**WEST SUSSEX COUNTY COUNCIL
STRATEGIC PLANNING CONSULTATION**

SUBJECT: Y/1/17/OUT-Outline Application with some matters reserved for the erection of 56No. dwellings with associated open space and creation of new access.

Bonhams Field, Main Road, Yapton, West Sussex, BN18 0DX

A5. PROPOSED SITE ACCESS

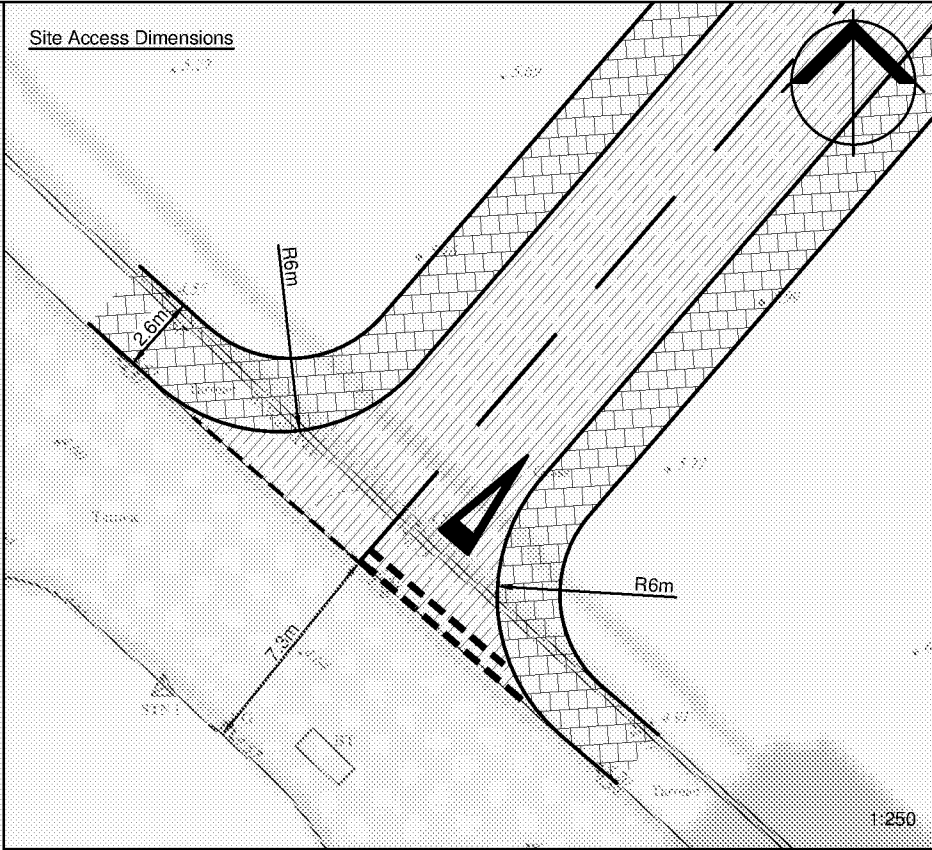
Access to the proposed is via a new 6 metre bellmouth. The applicant should include an area dropped kerbing and tactile paving to the link the existing footway over the new bellmouth; this should can be added at the Stage 2 Technical stage of the application. To the south east of the site a pedestrian link to Newpound Lane is to be provided.

The visibility splays have not been based upon 85th percentile recorded by ATC surveys. The splays have been based on the posted limit of 43 metres for a 30 mph road, for the recorded 85th percentile speed of 35.1 mph splays of 54 metres would be required to the north and 53 metres to the south. With the trimming of vegetation, the stated visibility splays are achievable in both directions. We would seek that a condition is attached to any granting of consent covering the inclusion of these splays. With the addition of the splays stated this junction is considered to be adequate to accommodate the vehicular movements arising from this proposal.

No part of the development shall be first occupied until visibility splays of 2.4 metres by 54 to the north and 2.4 by 53 metres to the south have been provided at the proposed site vehicular access onto Main Road in accordance with the approved planning drawings. Once provided the splays shall thereafter be maintained and kept free of all obstructions over a height of 0.6 metre above adjoining carriageway level or as otherwise agreed.

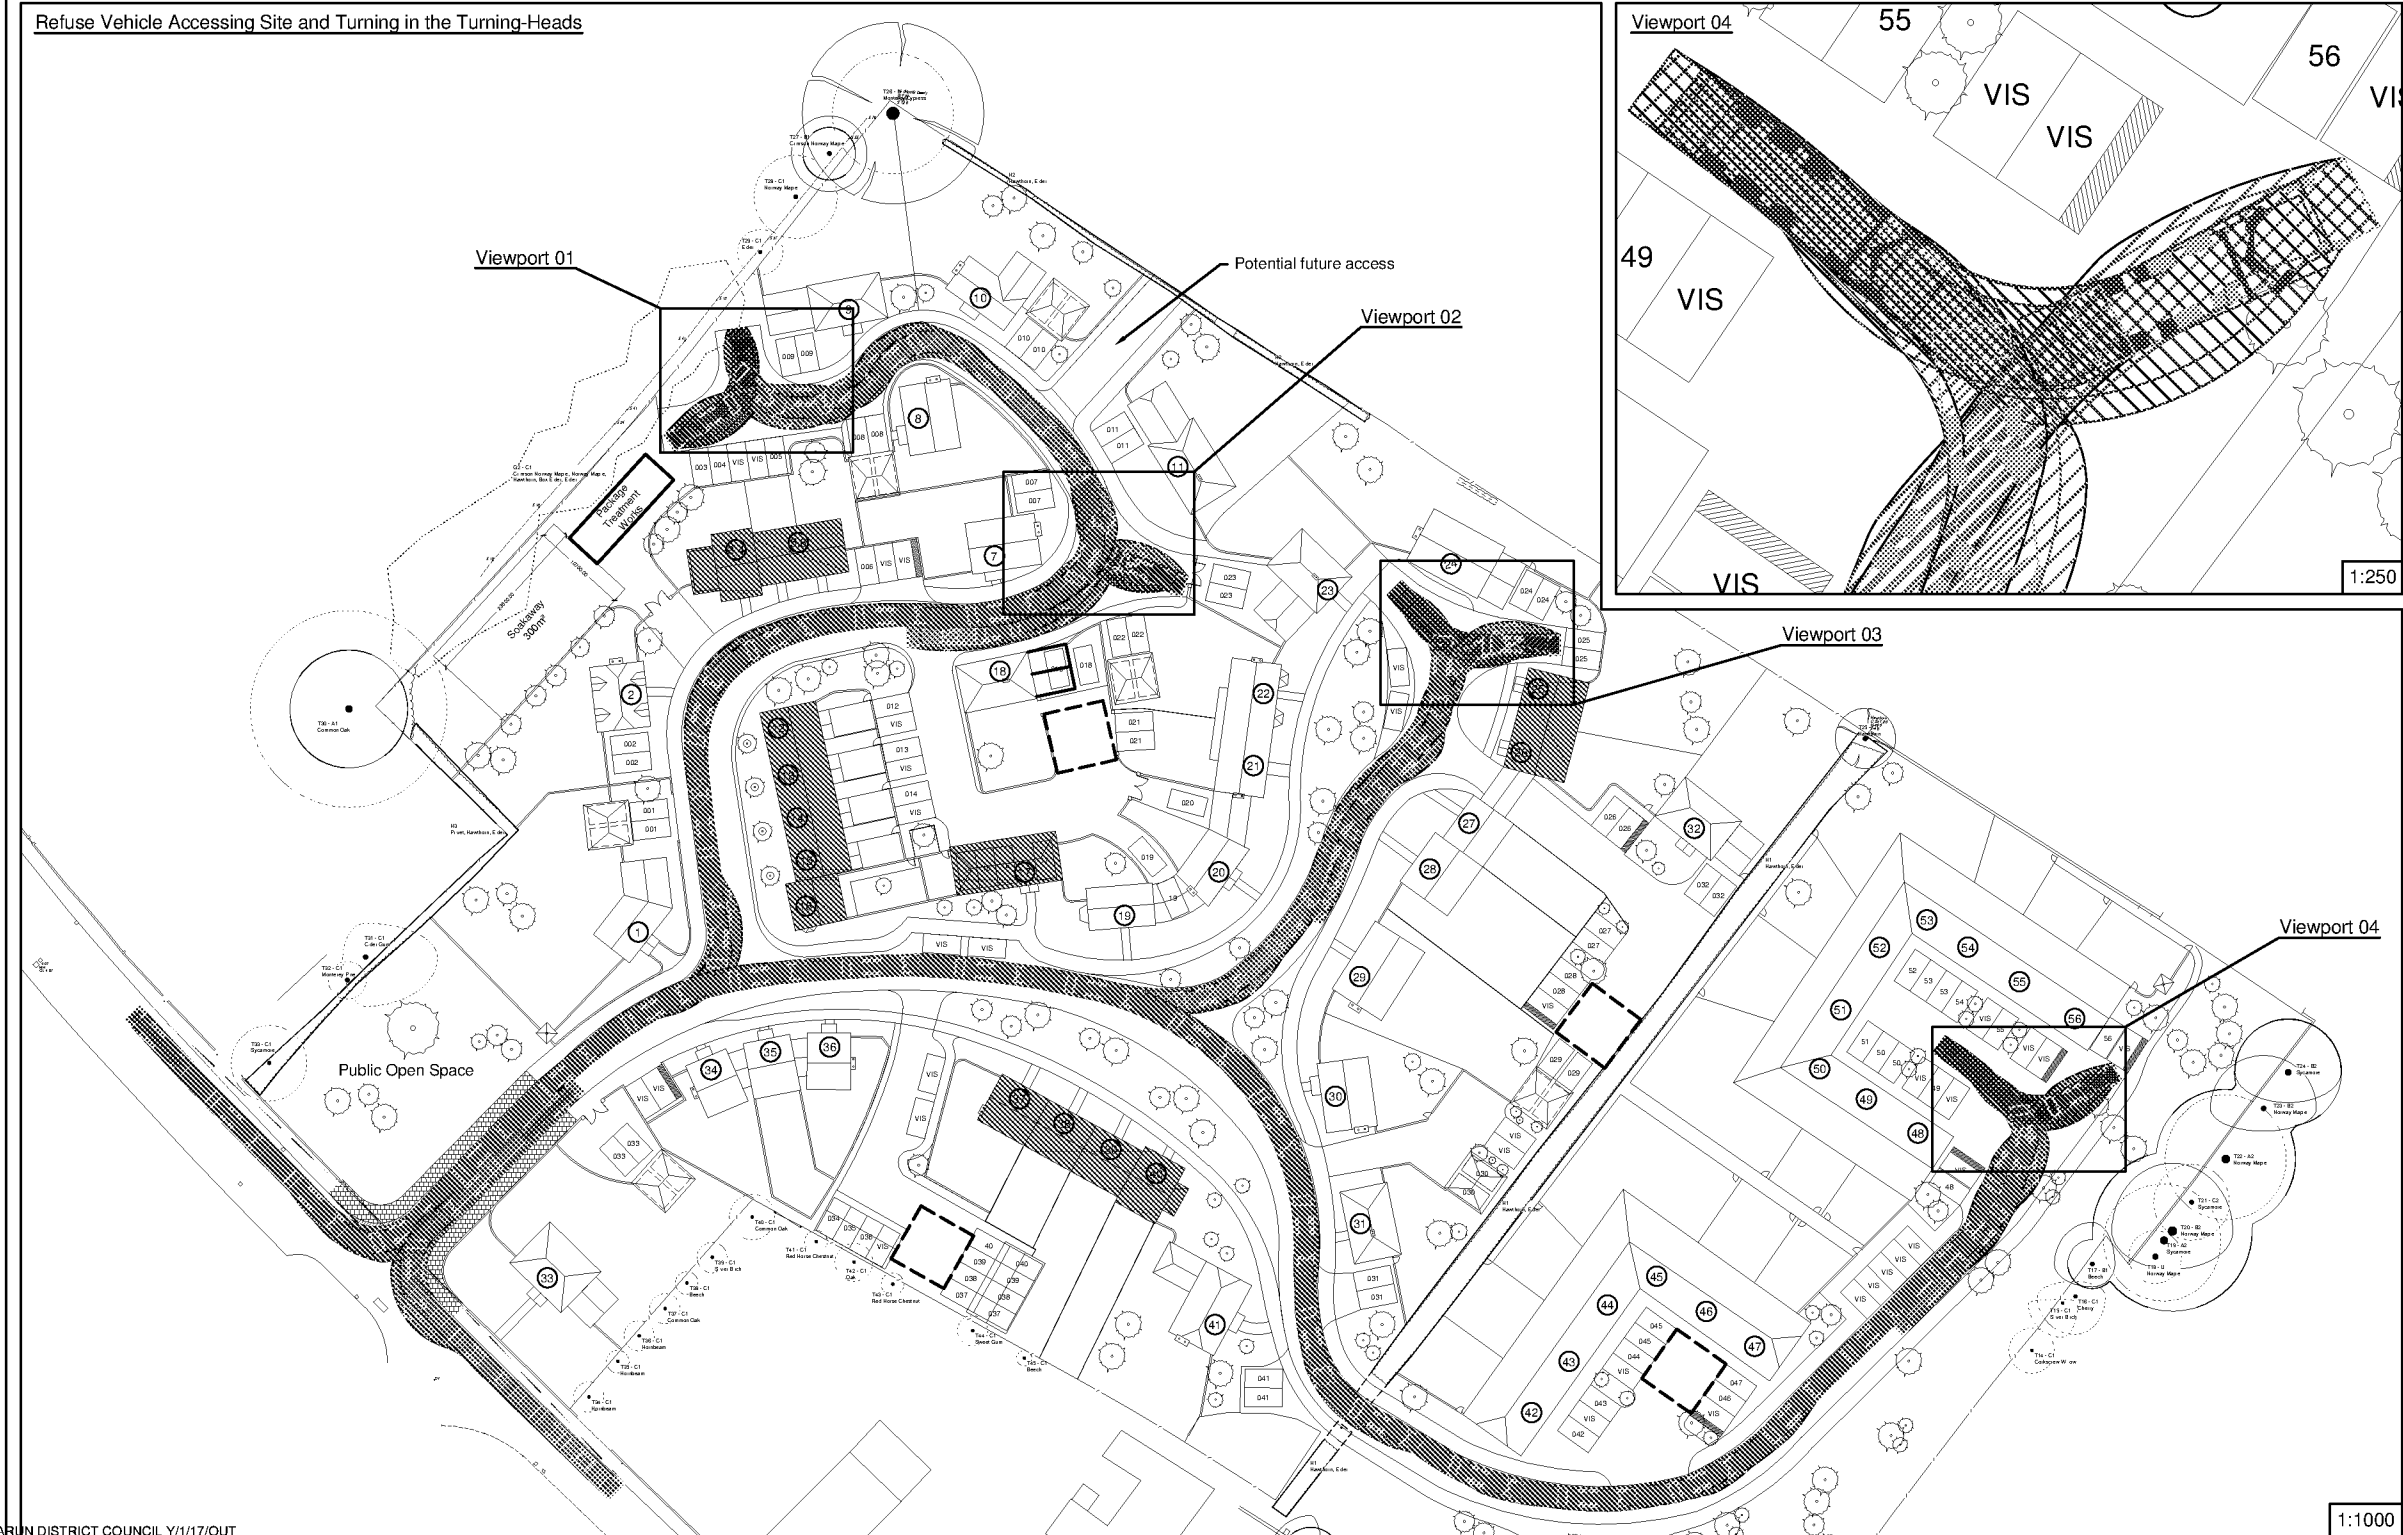
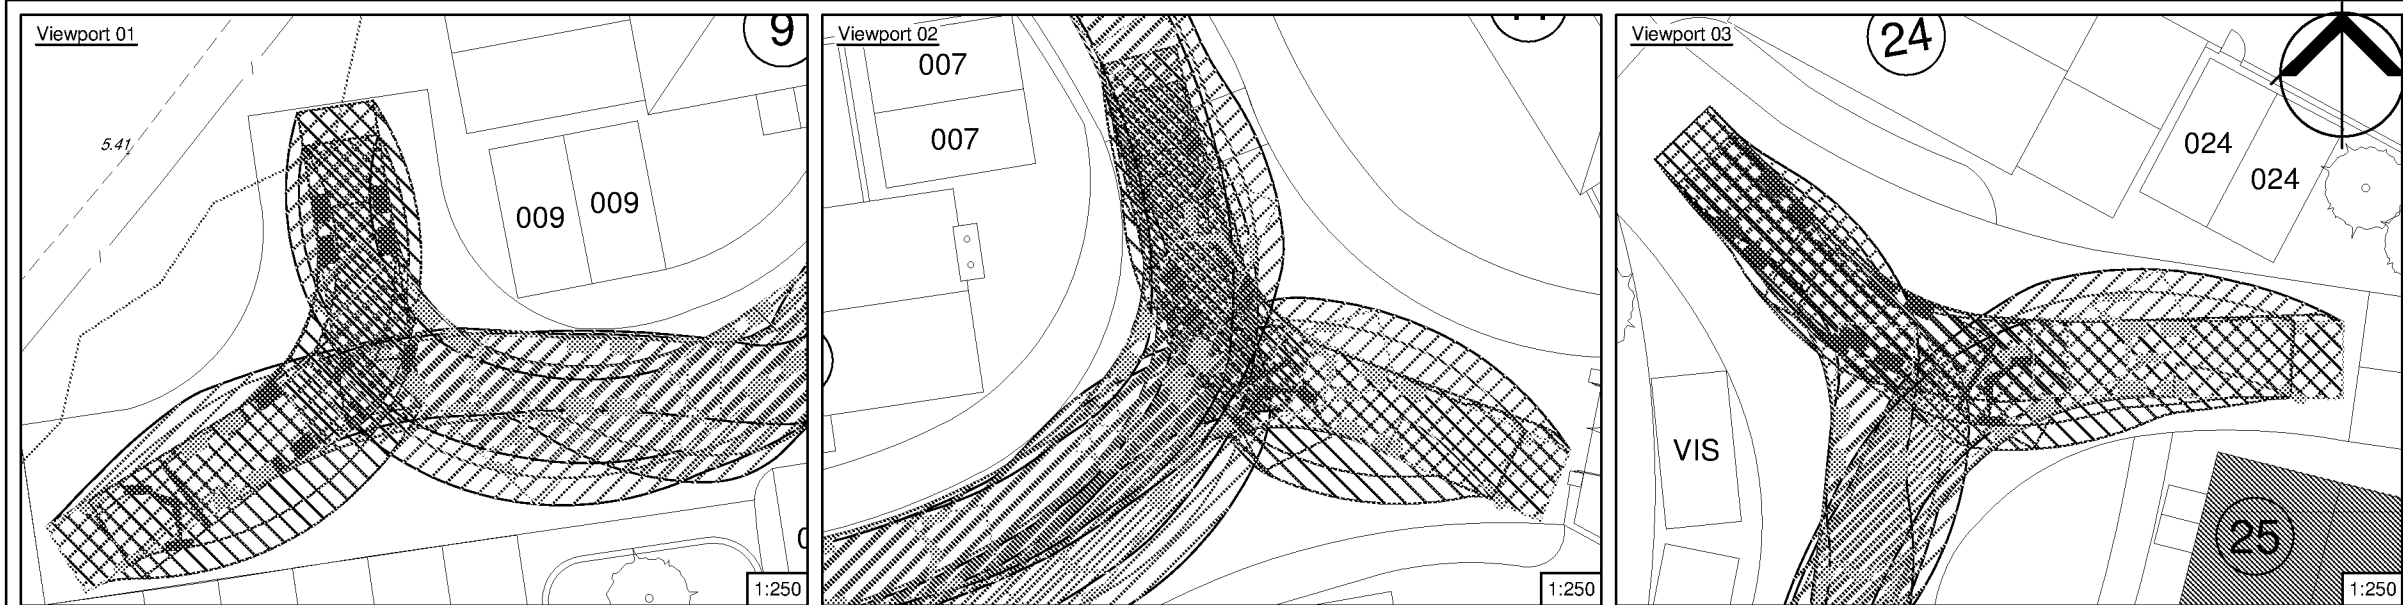
The RSA has identified 2 problems with the proposed access arrangements. The RSA viewed has got 'draft' stamped on it. The applicant will need to release a non-draft version so that we can keep it for our records. In summary the issues have been satisfactorily addressed within the Designer's Response and both elements can be sorted at the Stage 2 Technical stage.

Problem 2.1- The Audit Team found that there were some pieces of information missing from the location drawing. The Designer has responded and accepts with the Auditors recommendations further detail will be provided at the Stage 2 phase of the application.

Problem 2.2- Relates to the provision of tactile paving at the access as touched on in the introduction of this section, the Auditor suggests that this can be agreed at the Stage 2 Stage also. The Designer has also agreed to these provisions these amendments will be provided.

A8. SWEPT PATH ANALYSIS OF INTERNAL LAYOUT

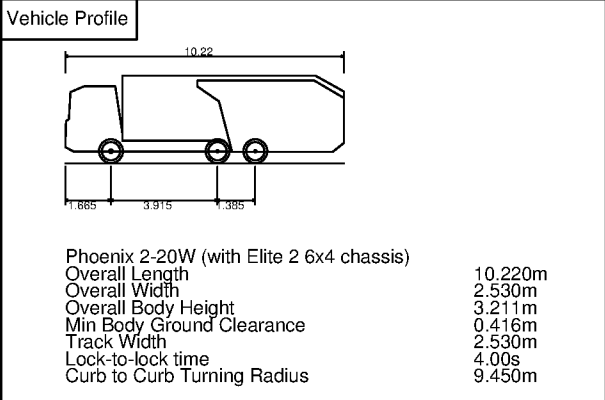
Whilst it is acknowledged that permission for the sites layout is not sought, there are no initial concerns with the indicative layout, designed in accordance with Manual for Streets (MfS) parameters. The access road should take the form of a 4.8 metre wide arrangement with the internal footways designed with 2.0 metre widths. This is considered suitable as this will be a low speed, low traffic environment. Refuse

collection will take place from within the site. Swept path diagrams have been provided showing larger vehicles turning paths within the site. The applicant should liaise with ADC's Waste Collection Team to discuss the suitability of this arrangement from their perspective.
